From: Laura Gibbons <Laura.Gibbons@arun.gov.uk>
Sent: 12 January 2021 12:03
To: Planning.Responses <Planning.Responses@arun.gov.uk>
Cc: Raymond Cole <Raymond.Cole@arun.gov.uk>
Subject: RE: Planning Consultation on: BN/142/20/OUT

Engineers Comments Regarding Surface Water Drainage

Application No: BN/142/20/OUT

Site Address: Land south of Barnham Station Barnham

FIGURE 48. Plan showing the main access to the site from Marshall Close (i-transport)

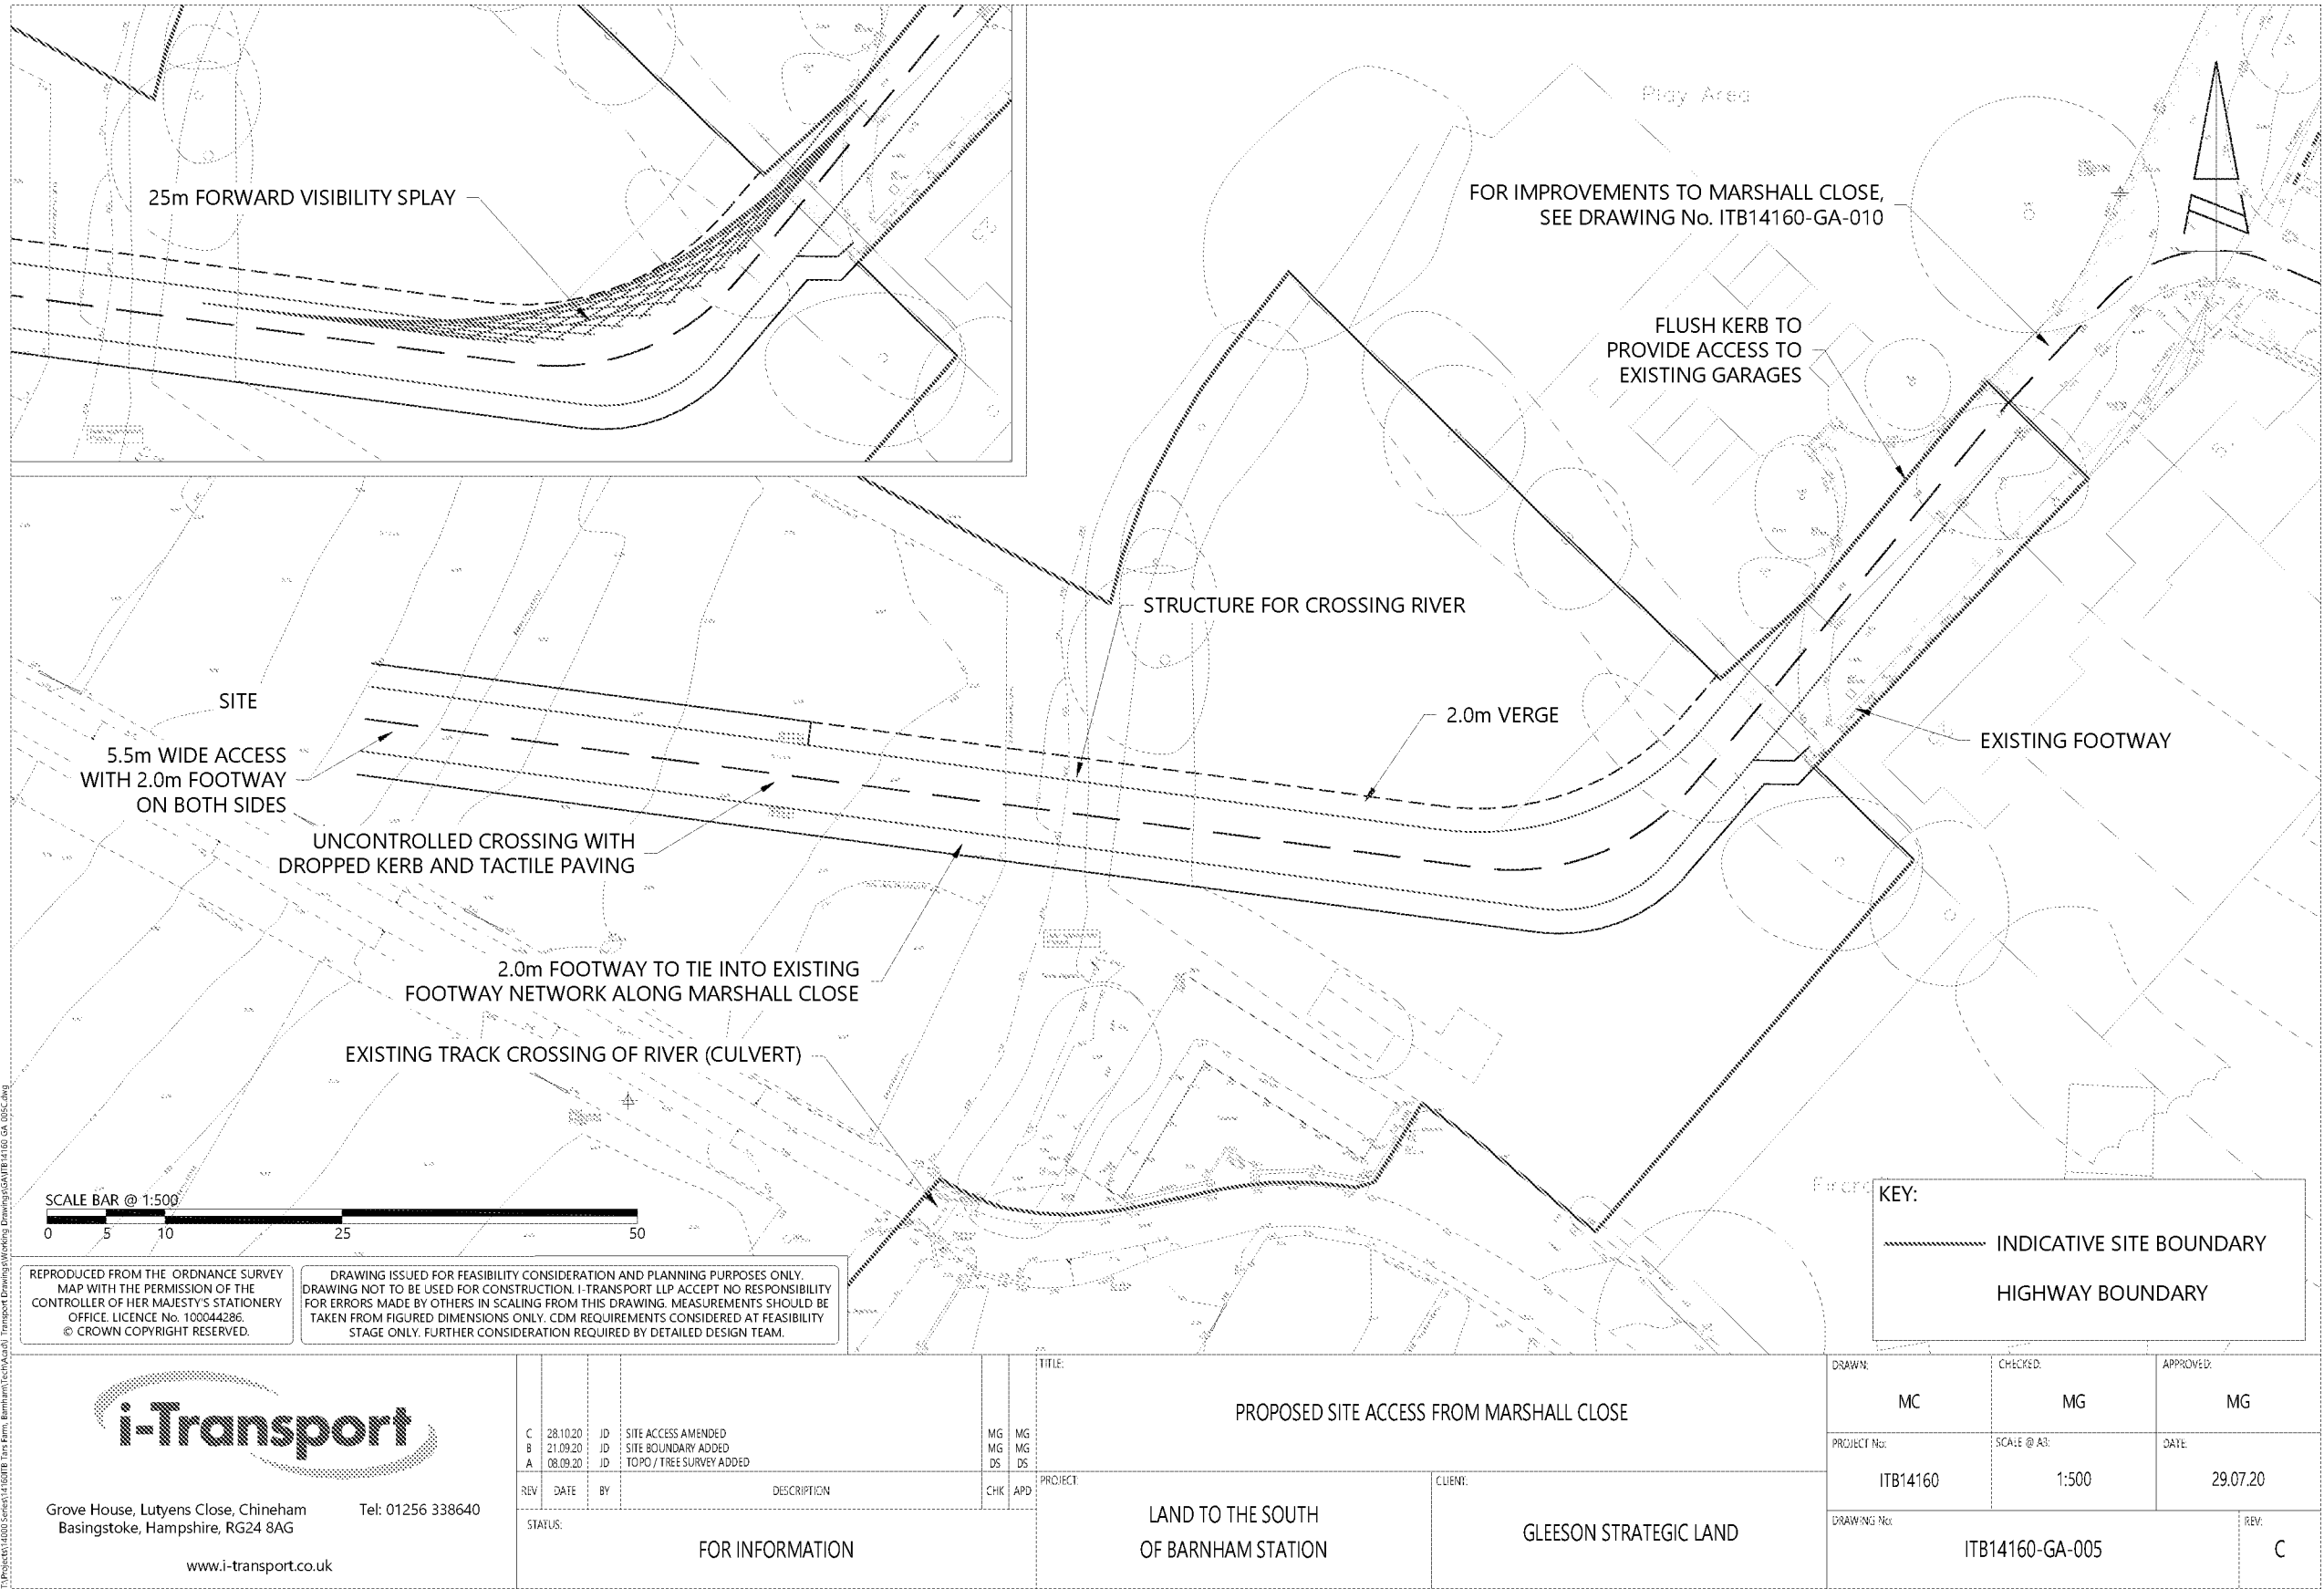
We believe that the proposed access will cross the surface water drain that serves Marshall Close and outfalls to the Barnham Rife. This requires further investigation and may require work to facilitate the crossing.
